## Engineers Comments Regarding Surface Water Drainage

| <b>Application Reference:</b>   | P/59/25/DOC                                                                                                                                   | <b>Reviewer Reference:</b> | ADC/EXT2/D2134/74 |
| <b>Site Name:</b>               | Sefter Farm Pagham Road Pagham PO21 3PX                                                                                                       |                            |                   |
| <b>Application Description:</b> | Approval of details reserved by condition imposed under reference P/117/21/PL relating to condition number 7 - surface water drainage scheme. |                            |                   |

CLIENT Barfoots Of Botley
PROJECT Setter Farm East
TITLE Site Layout - Proposed Drainage - Sheet 2

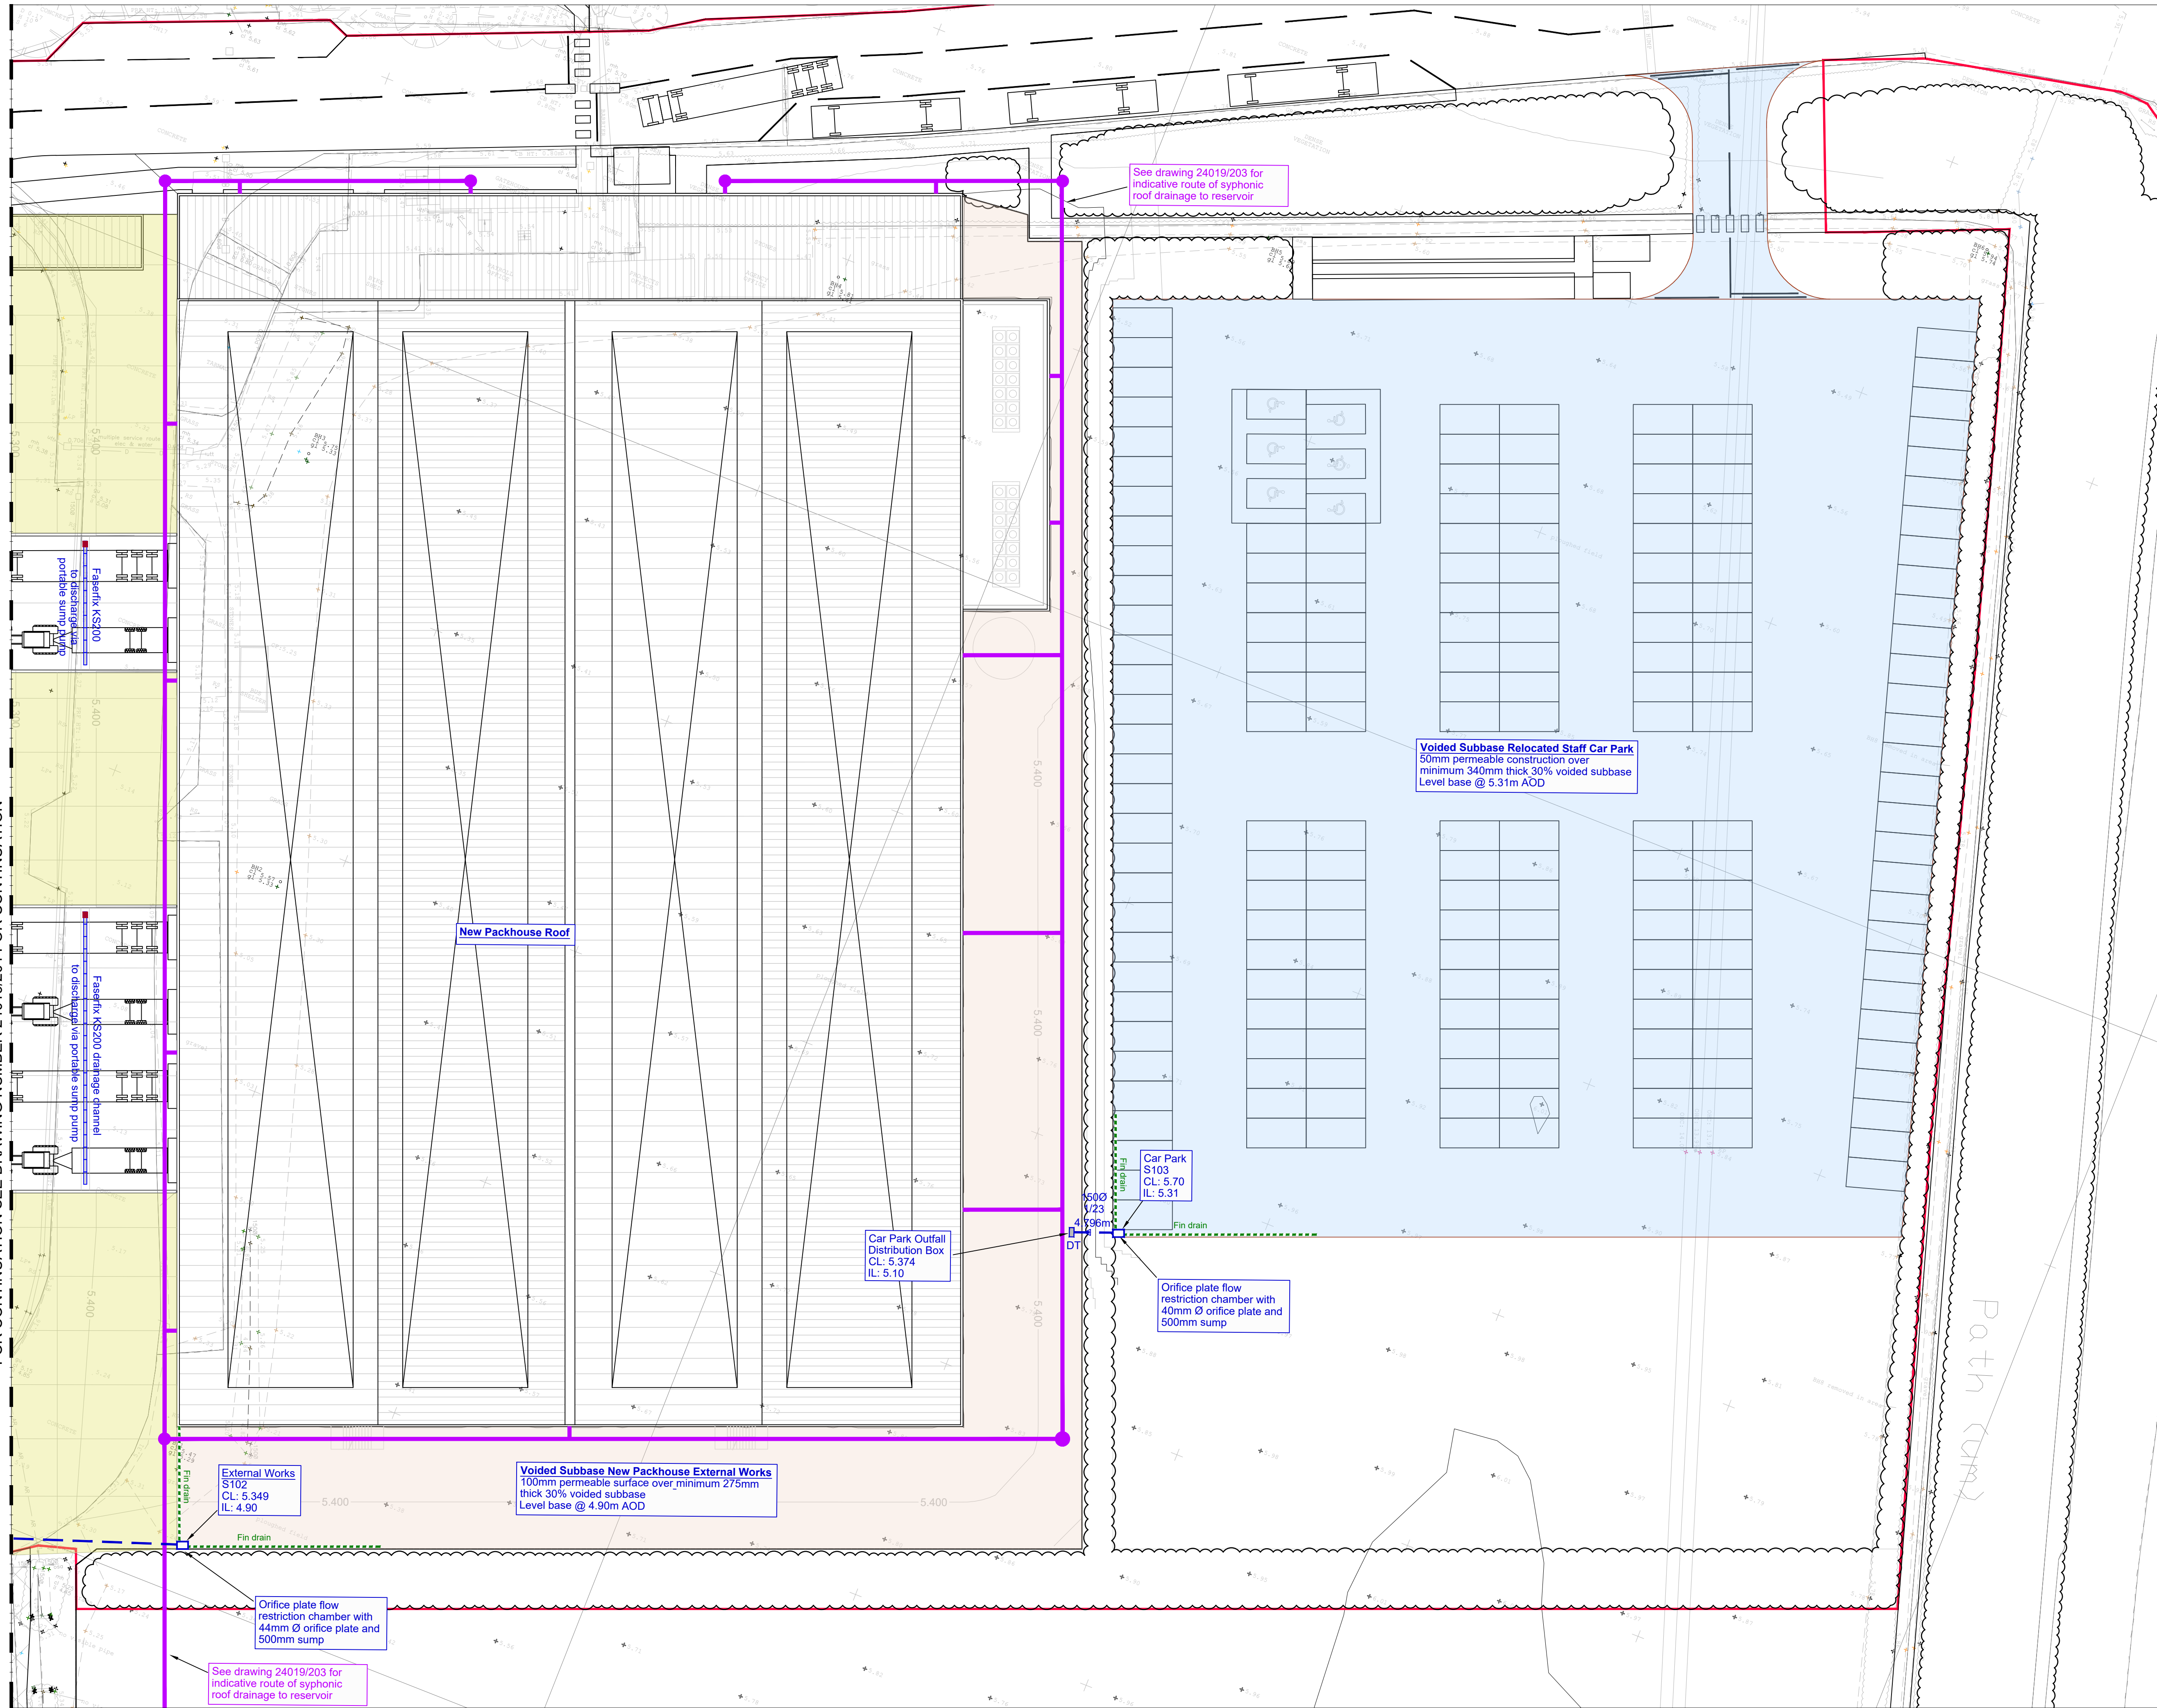
| 7.  | The symphonic roof strategy is noted to be designed by others, please provide some further information to verify that there will be no connections and/or potential breach of this system which may inundate the other SW drainage networks.<br><br>Noting parts of this network will be 'above ground', how will this link to the reservoir tank? |  |  |  |  |

CLIENT Barfoots Of Botley	
PROJECT Setter Farm East	
TITLE Proposed Site Sections - Sheet 1	
DRAWN A Davies	DATE Apr 2025
ENGINEER S Doughty	CHECKED SRM
SCALE NTS	PROJECT NO. 24019
	REV. 311 -

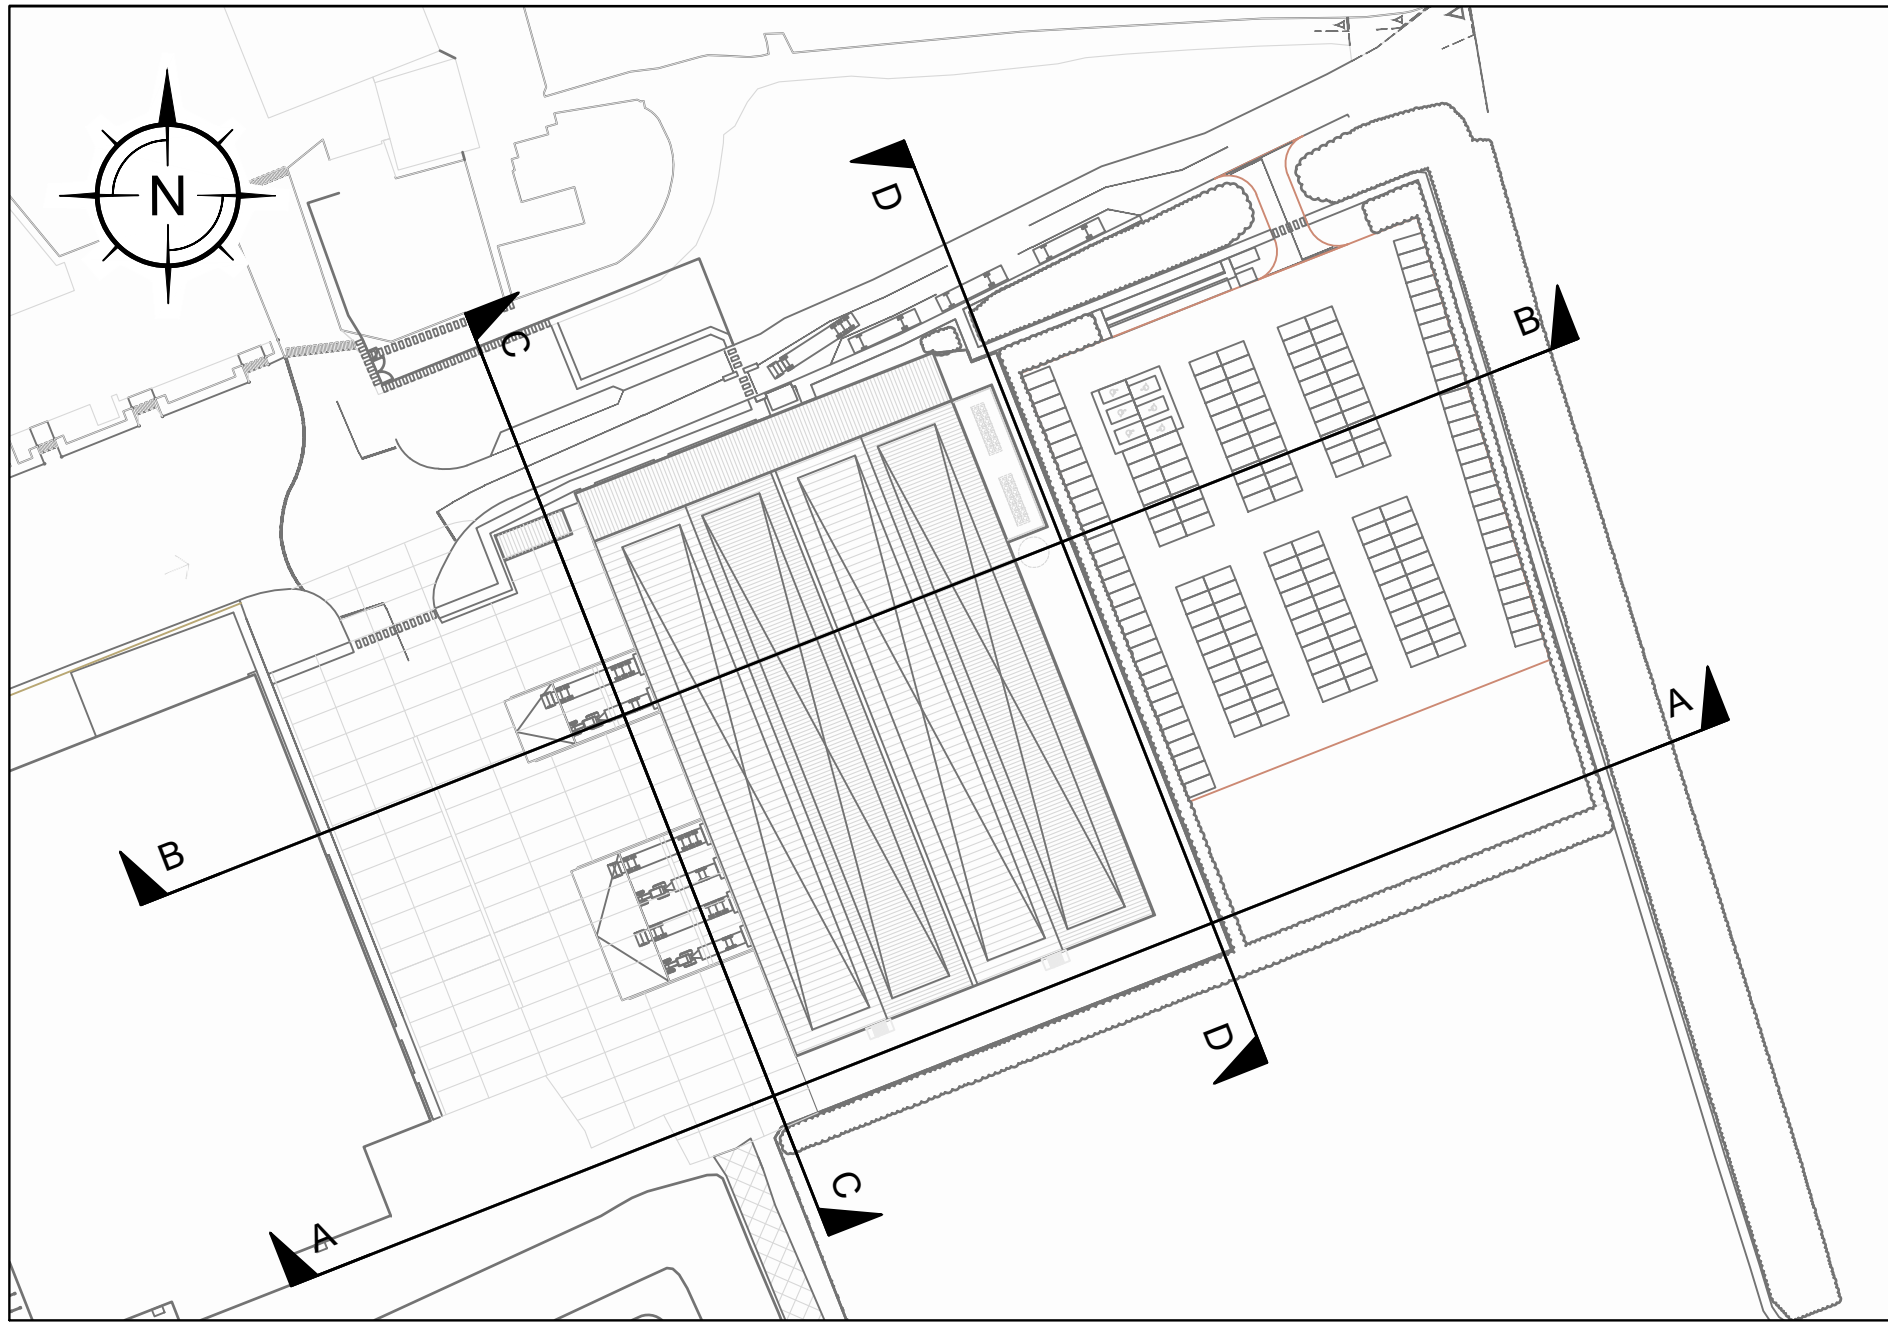
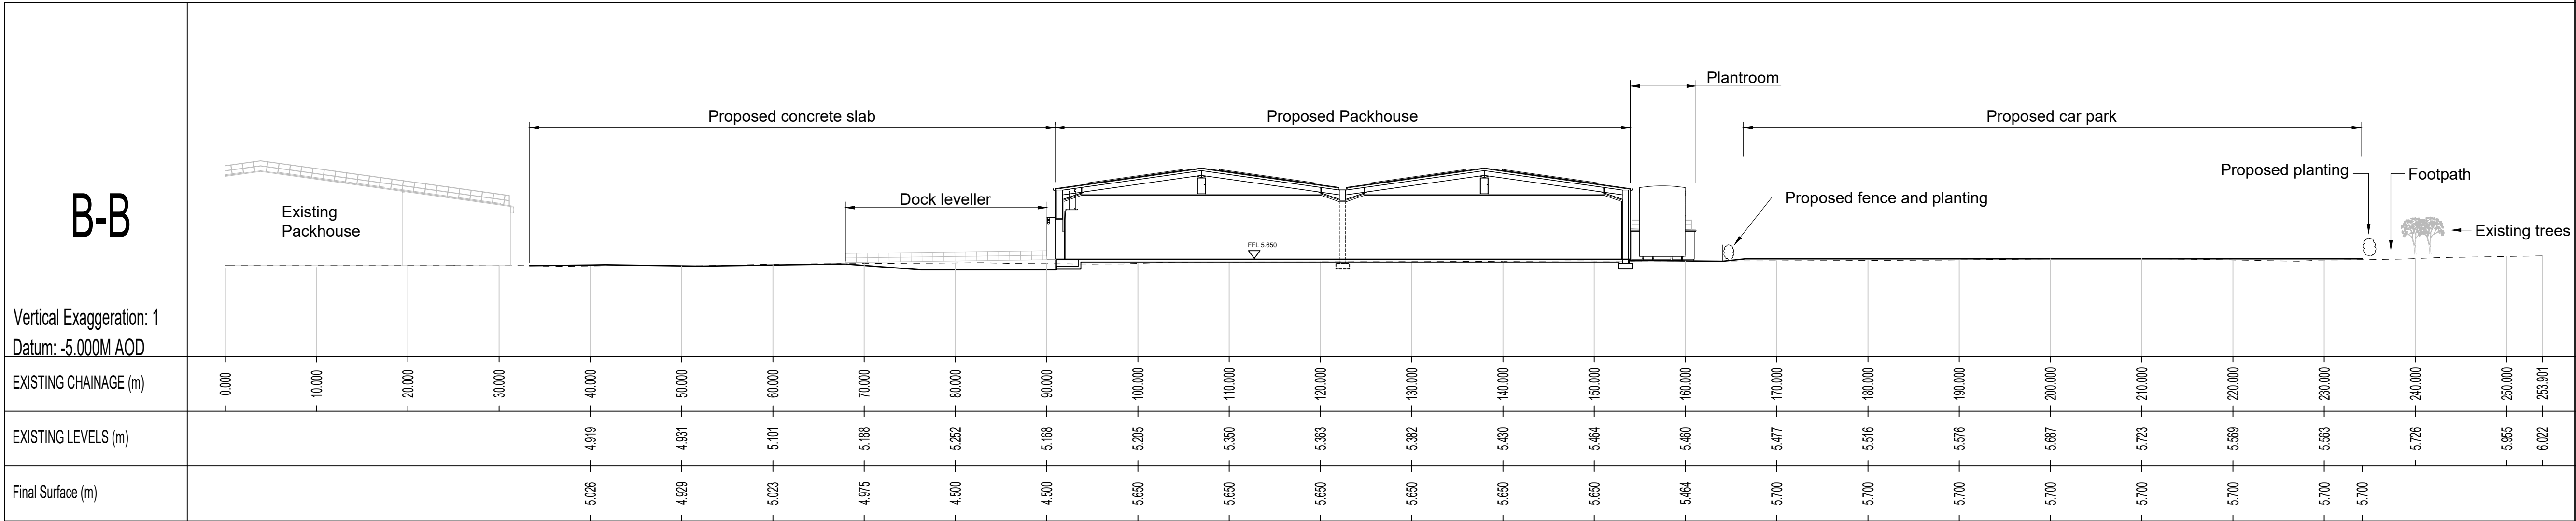
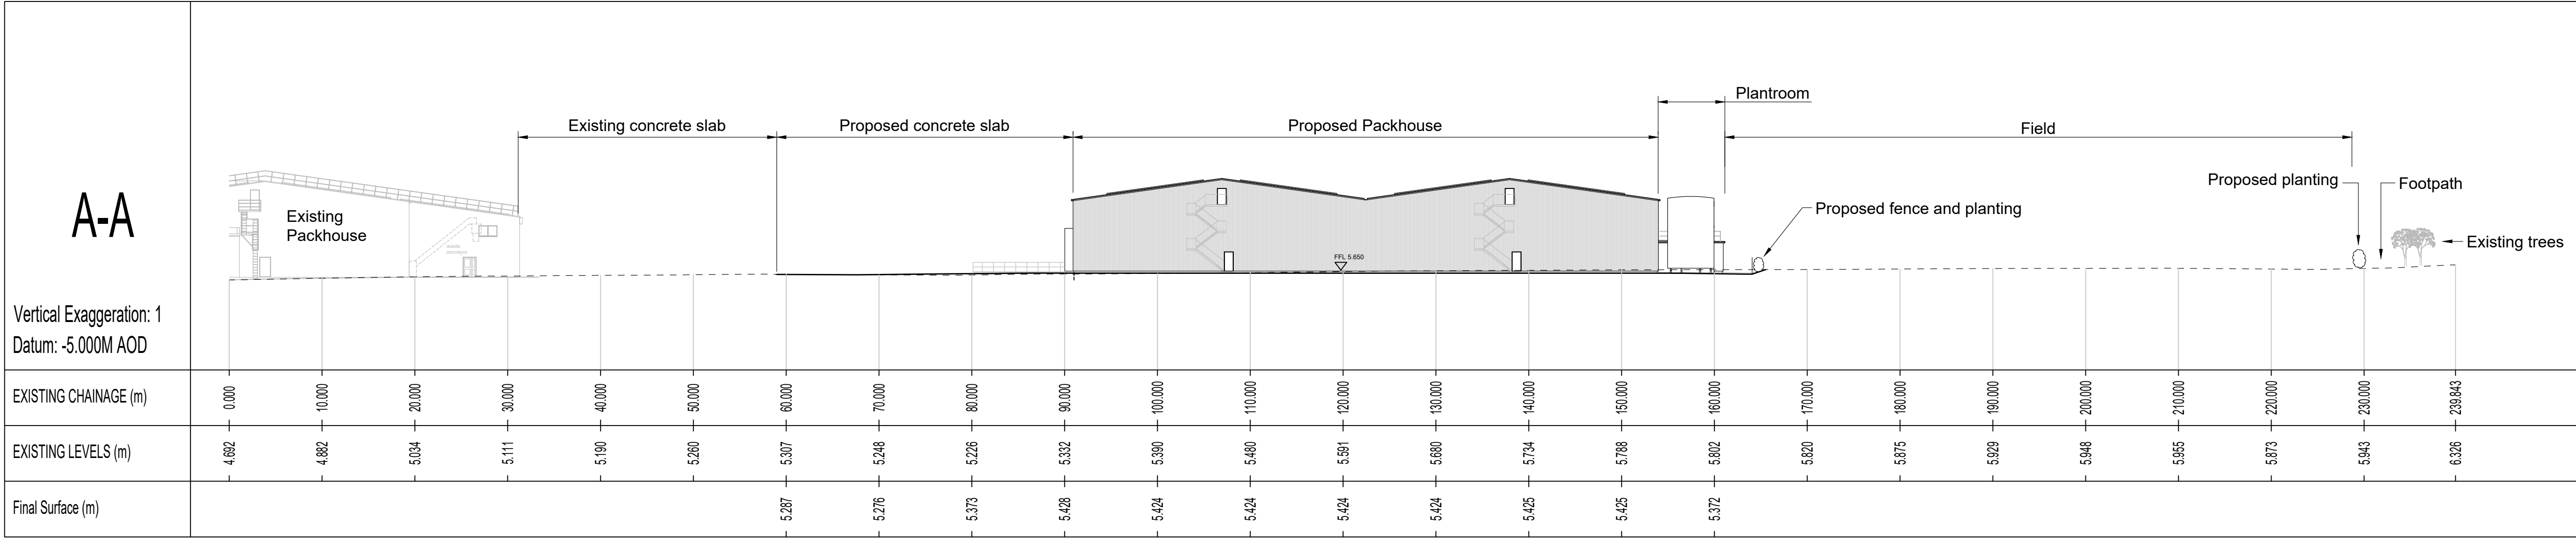
| 9.  | Whilst the proposed yard and permeable parking are proposed to be laid very flat, the site sections nor surface finishes highlight any boundary kerbs/edging which may have a role in controlling run-off, please confirm.                                                                                                                         |  |  |  |  |
